From: William Summerlin [REDACTED]@stateraenergy.co.uk>
Sent: 21 February 2024 12:05
To: Nsipconsultations@ukhsa.gov.uk
Cc: Contact Thurrock
Subject: RE: Thurrock Flexible Generation - Reg 6 Notice

From: Nsipconsultations <Nsipconsultations@ukhsa.gov.uk>
Sent: 20 February 2024 8:59 AM
To: Contact Thurrock <contact@thurrockpower.co.uk>
Cc: Nsipconsultations <Nsipconsultations@ukhsa.gov.uk>
Subject: FW: Thurrock Flexible Generation - Reg 6 Notice

“The NMC would allow for an increase in the number of gas reciprocating engines that can be installed at the site from “up to 48” to “up to 100”.”

Figure 4.15: Operational noise contour, day.

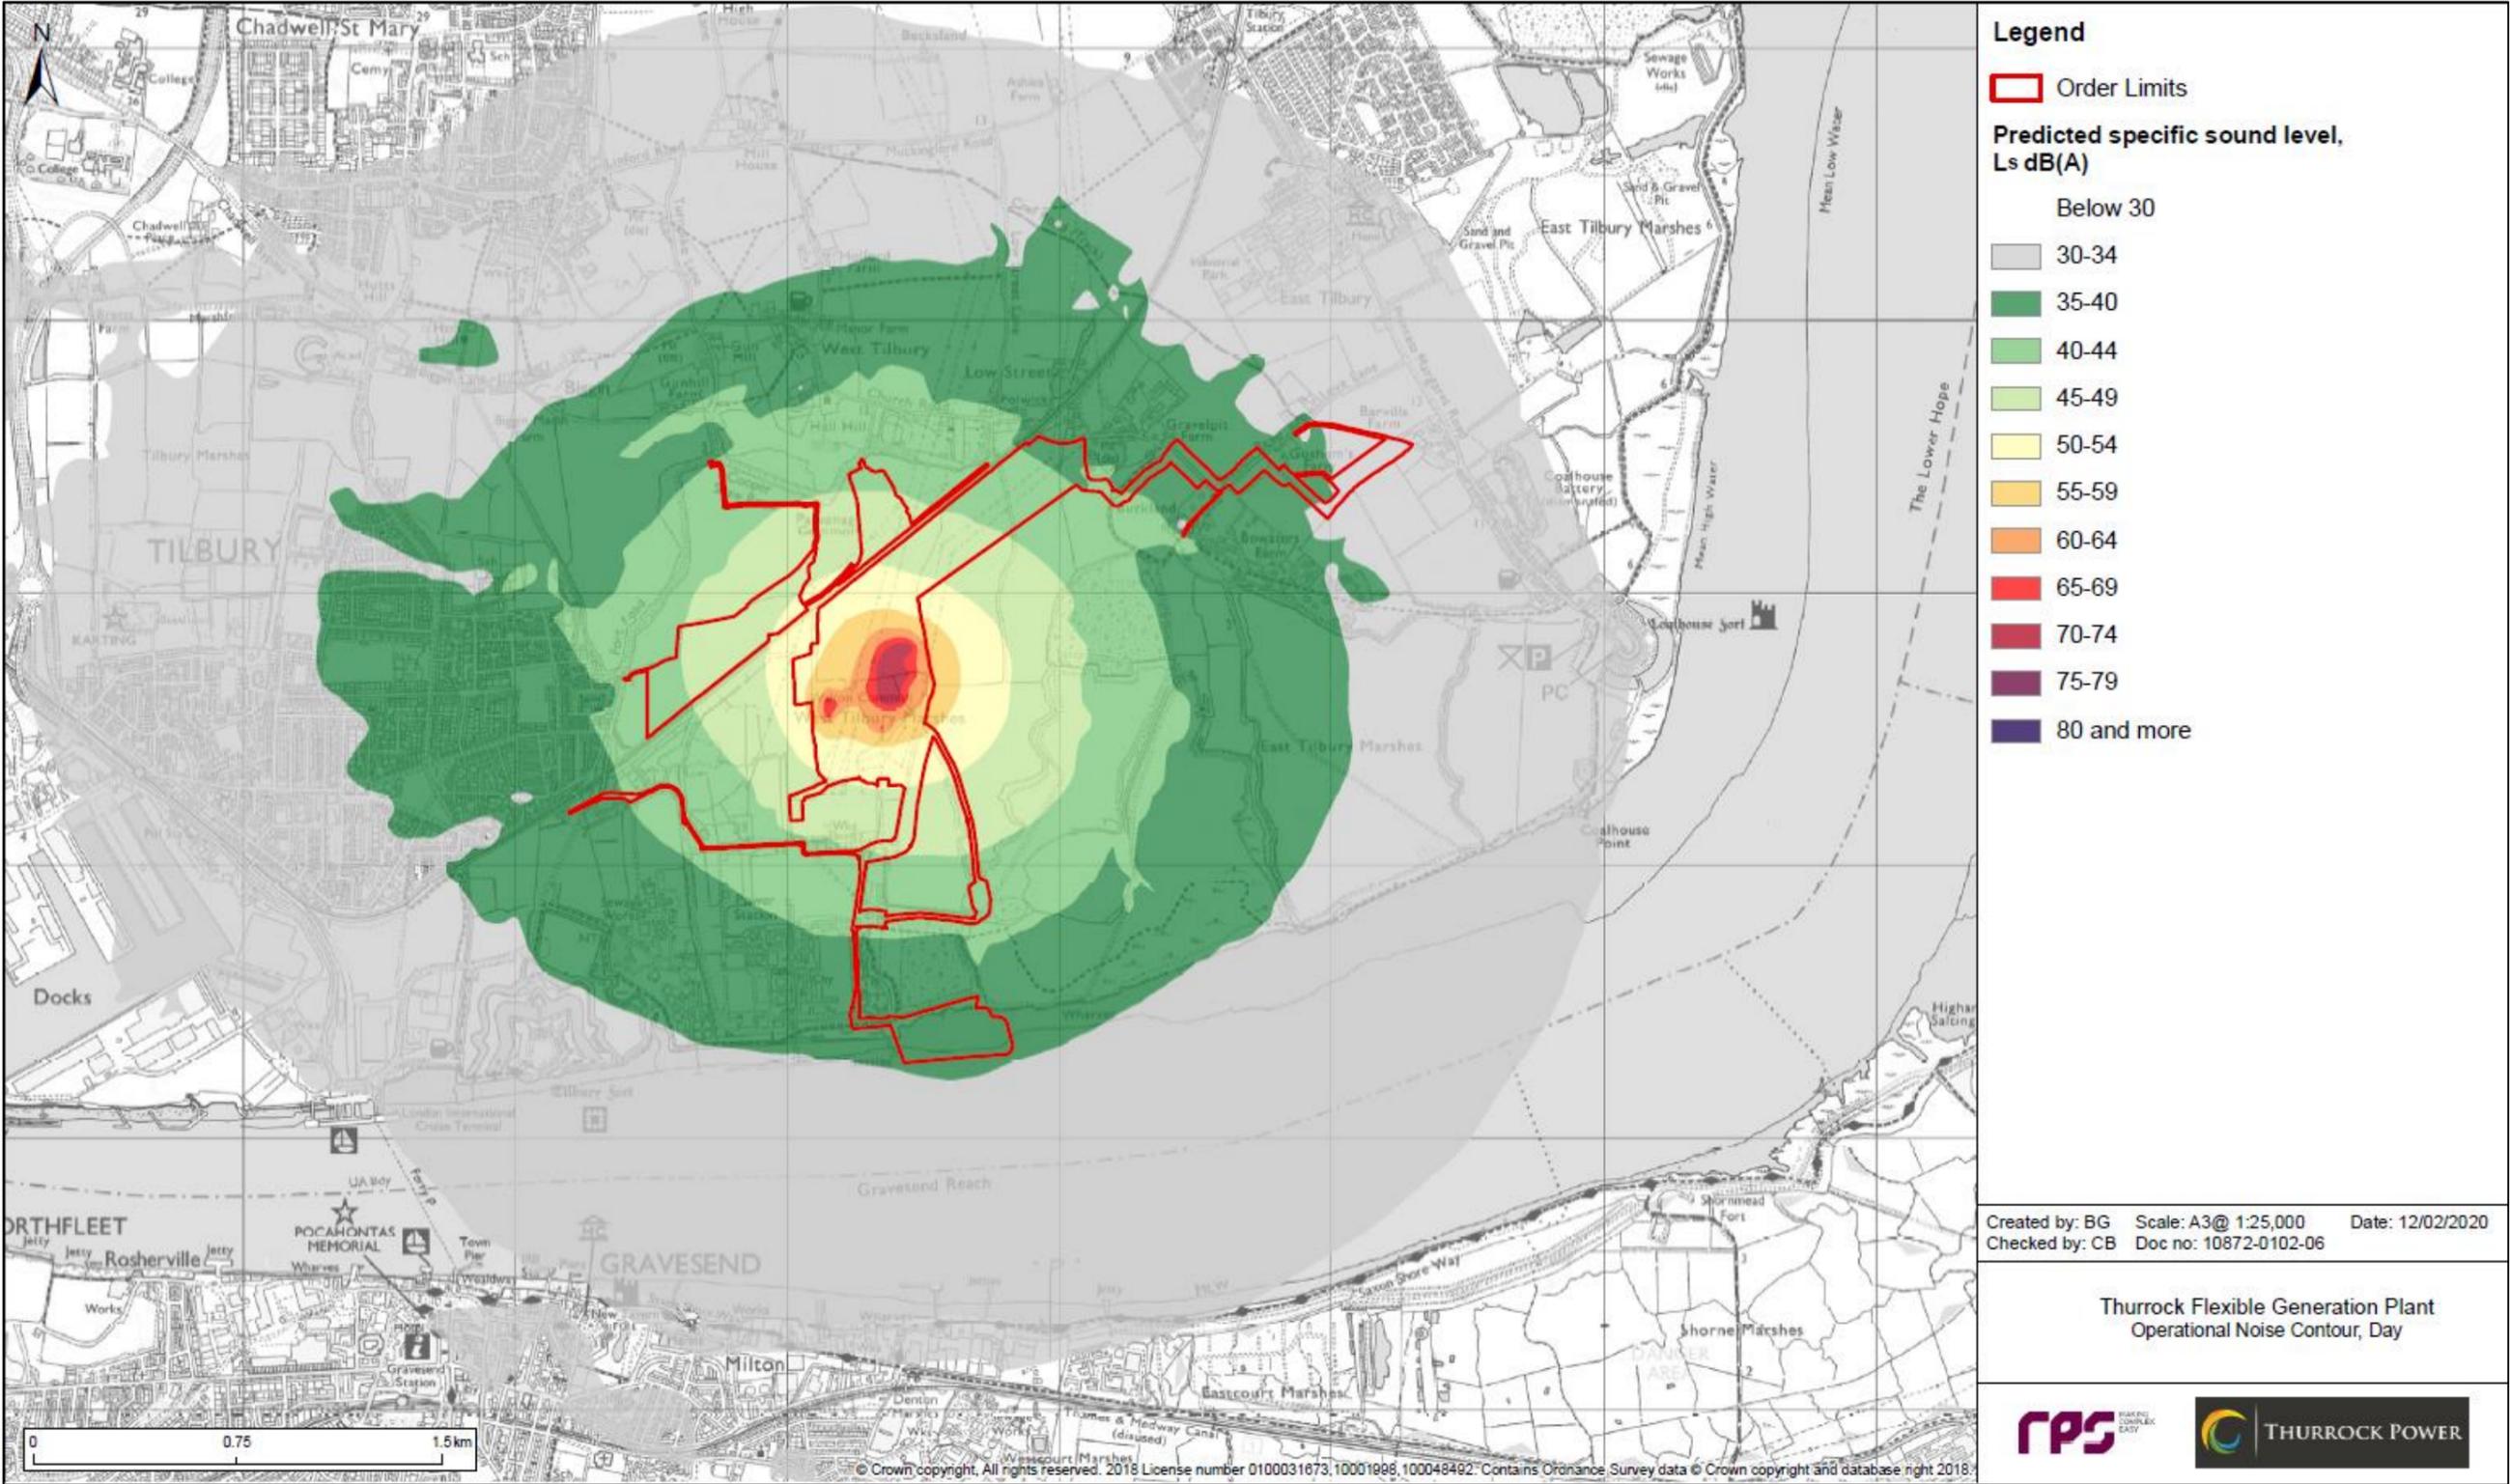
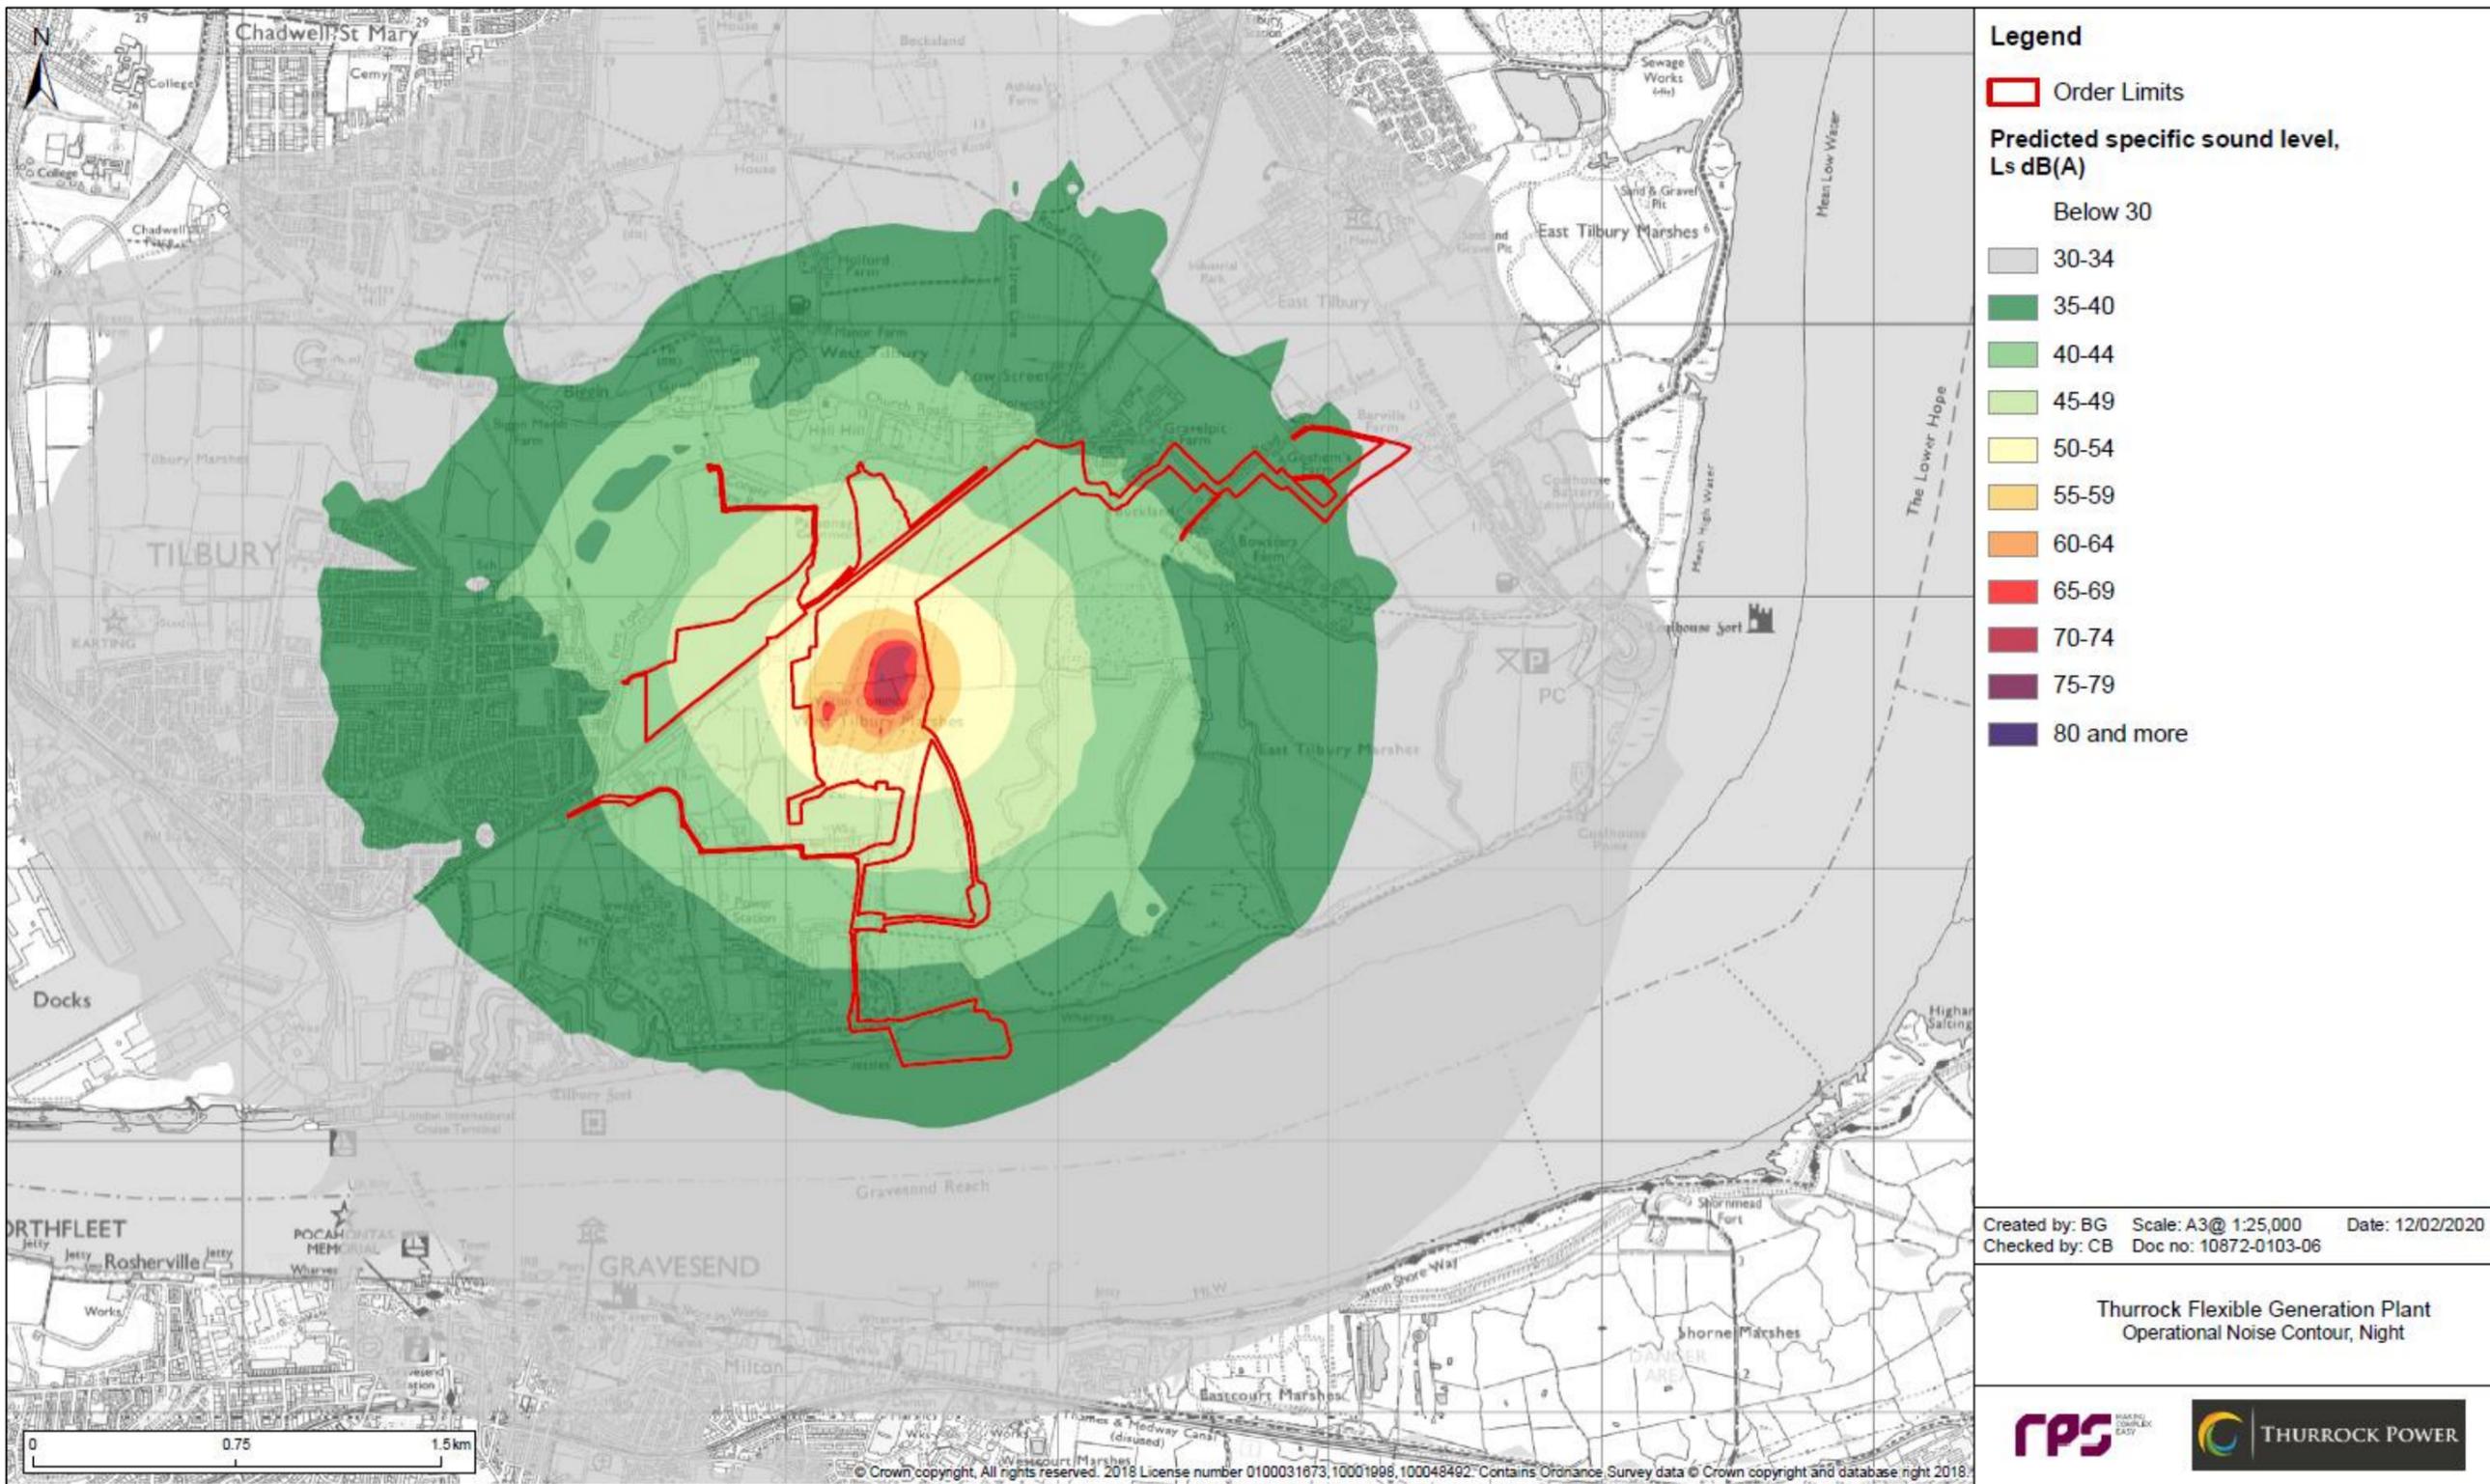
This change in the number any type of engines is likely to have an impact on the sound they produce. e.g. a small motorcycle engine sounds different to a large car engine. I cannot find any information that this potential change in sound impact has been assessed.

Can this be included in the application?

Requirement 16 of the made DCO controls operational noise by prohibiting the rating level at any residential receptor exceeding 45 dB LAr,Tr. This is a requirement that covers both the gas element of the project and also the battery element of the project (being a 300MW battery at 2-hour duration that is currently under construction).

Inherent in the design and noise mitigation of both the battery (which is under construction) and the gas (which will be built in phases in the coming years) is a need to comply with requirement 16. Please note that the LAr, Tr rating level caters not just for a specific sound level but also an adjustment for any characteristic feature for the sound in accordance with BS4142 (e.g., the motorcycle vs large car point you made in your email).

As a result, there is no update the environmental statement necessary which is why this change can be progressed as a non-material change. It's also worth noting that noise emitted from any constructed gas engine element of the scheme will be regulated by an environmental permit for operation.
